CITY OF ALBUQUERQUE

December 20, 2024

Re: Gibson In-N-Out
Traffic Impact Study (L15D047)
DRAFT October 2024
Via email jkruse@lee-eng.com

CIVIL ENGINEER:
MSI ENGINEERING, INC.
 CIVIL ENGINEERS AND LAND SURVEYORS SPECIALIZING IN SITE DEVELOPMENT
 301 NORTH SAN DIMAS AVENUE, SAN DIMAS, CA. 91773
 (909) 305-2395 FAX (909) 305-2397
 Aaron D. Pellow
 AARON D. PELLOW R.C.E. 27112

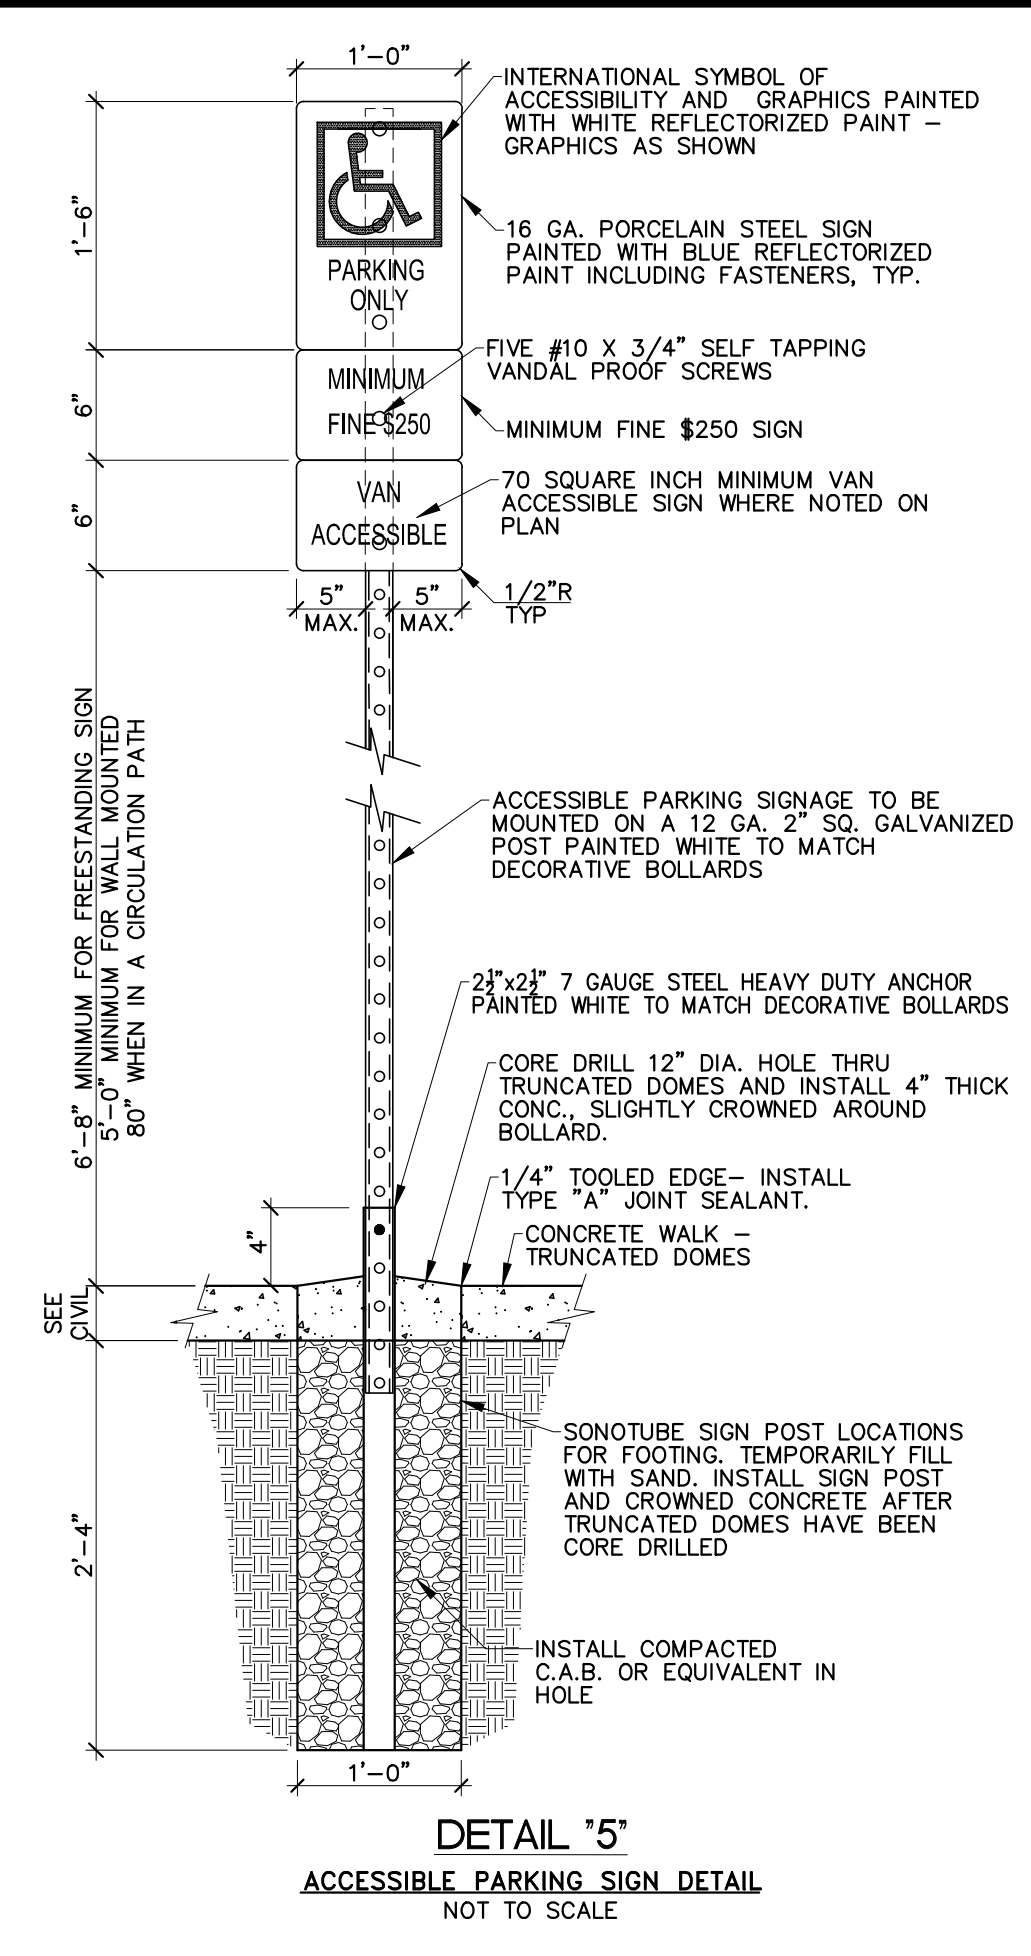
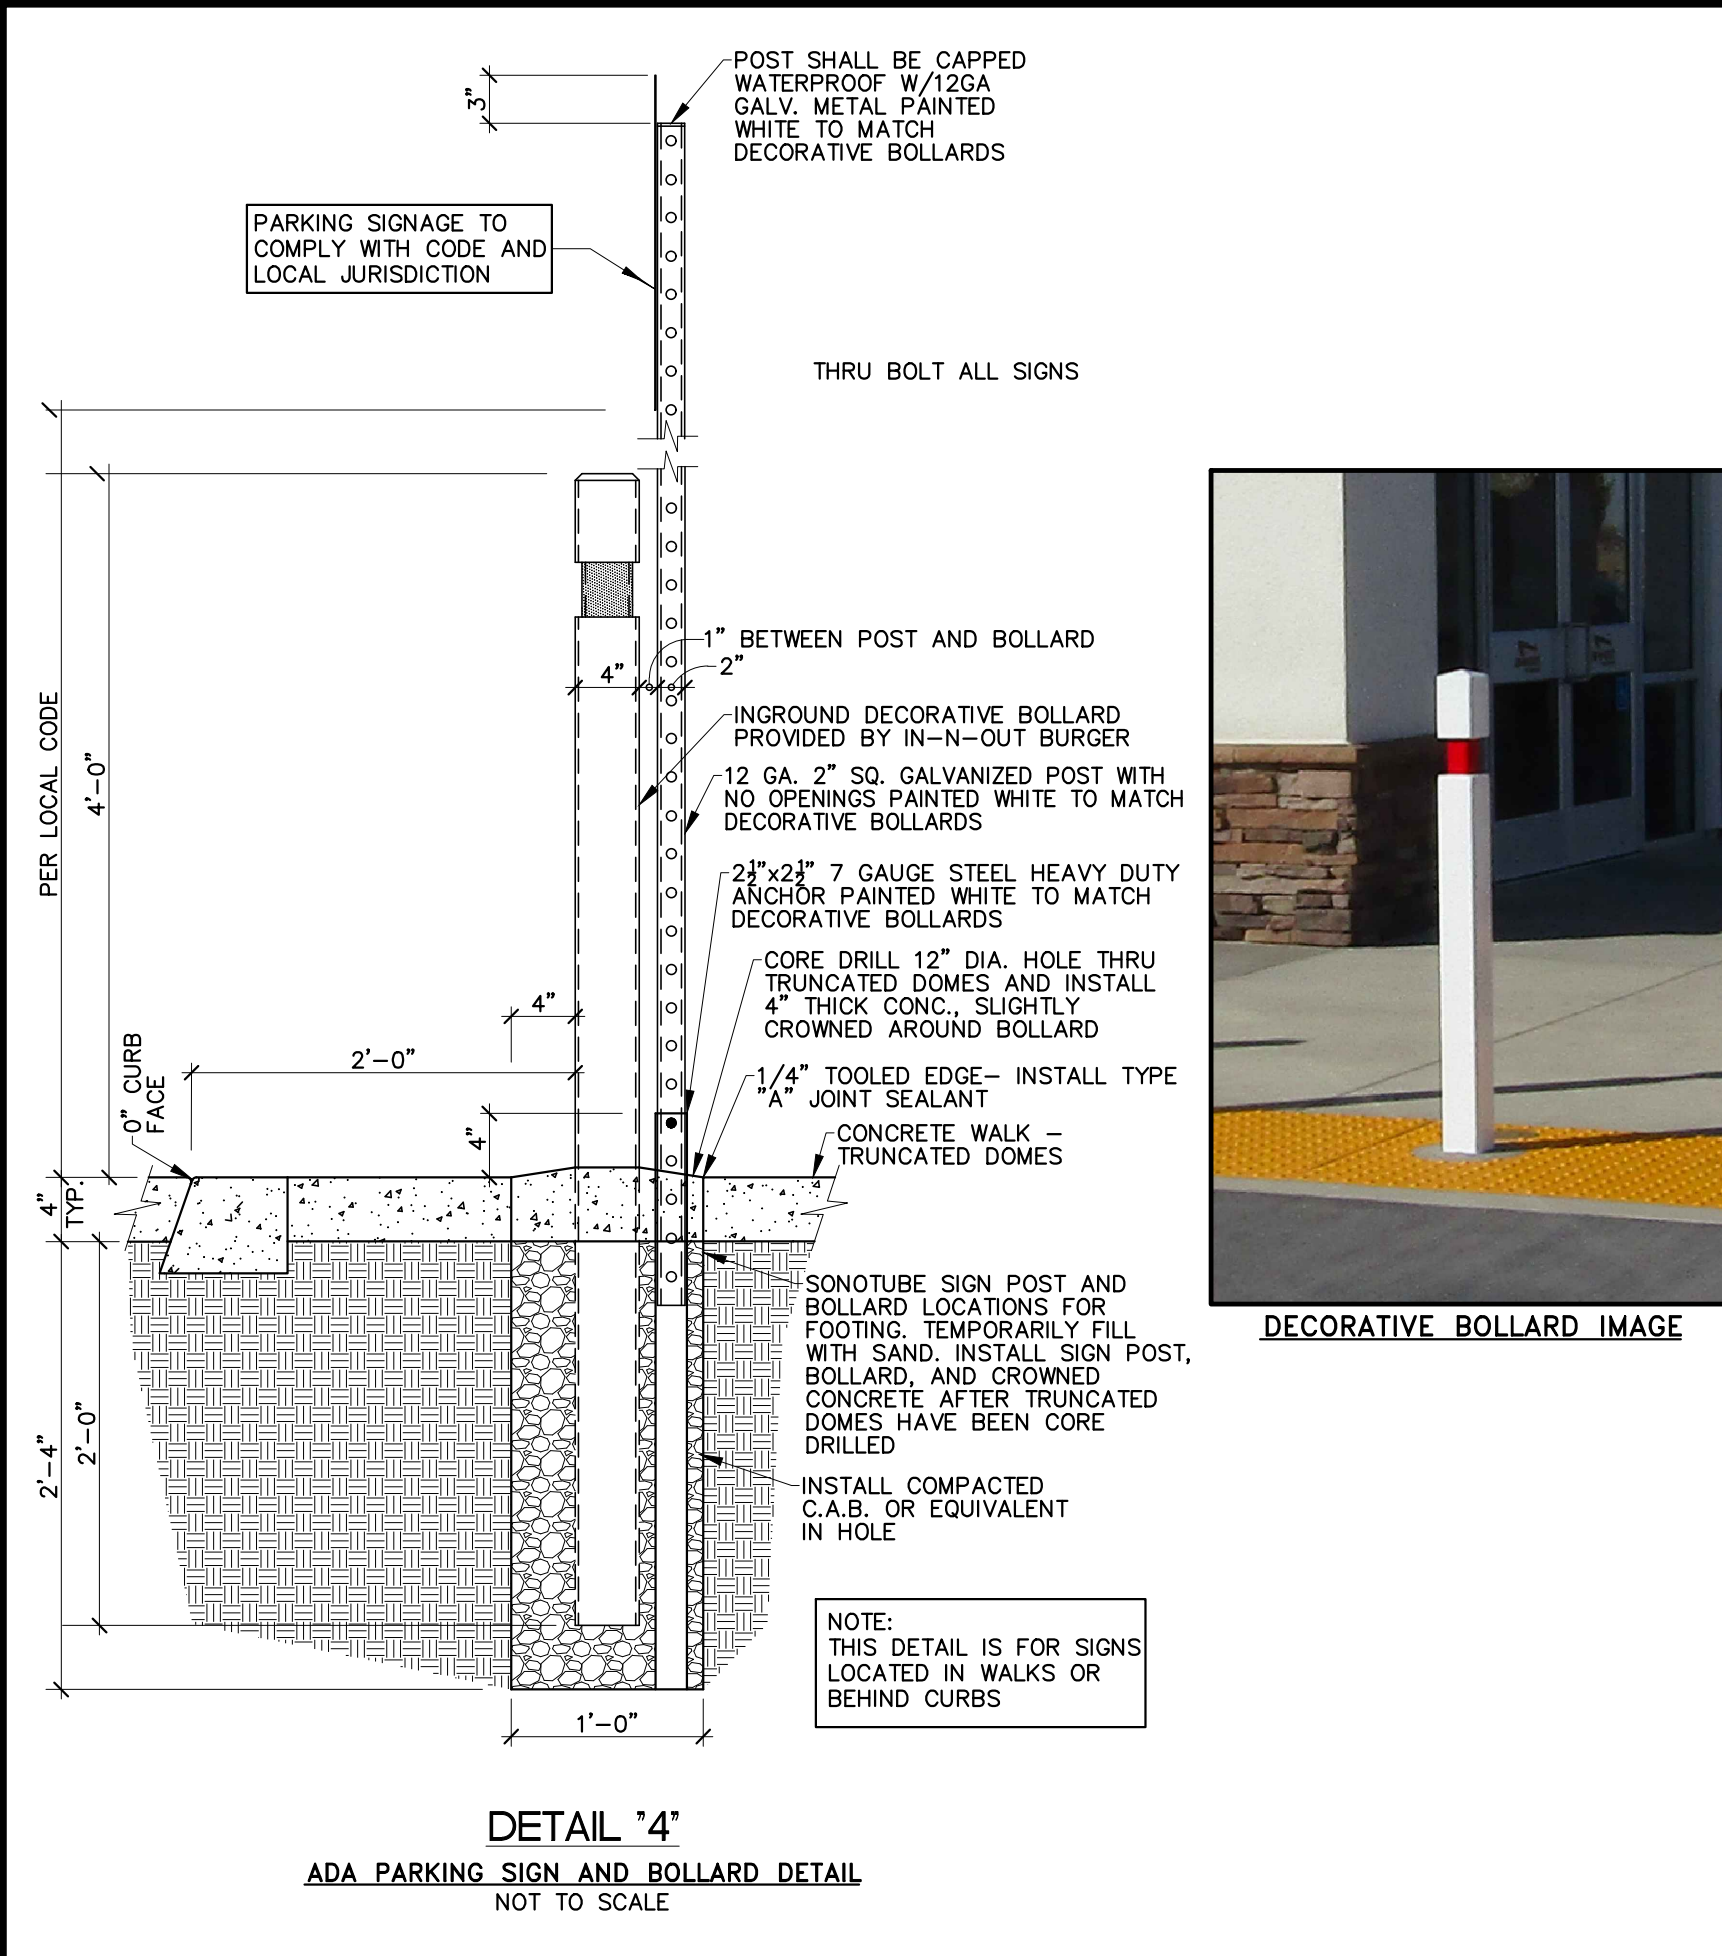
1. Trips were assigned to a driveway three, which does not exist. See HCS Two-Way Stop-Control Report pp 130 and 131, 158 and 159 of 173. Reassign trips to the two driveways shown on the Site Plan. Additional comments/questions may arise after the revised information is presented.

3. The Site Access and Justification paragraph mentions three access driveways, whereas, the Site Plan shows 2.
4. Provide the methodology/calculations used to determine the 160 ft turn lane length: decel, storage and taper or 95% percentile queue length.

5. Provide a clear 11" x 17" site plan that shows the dimensions and striping discussed in the Auxiliary Lane Analysis section.
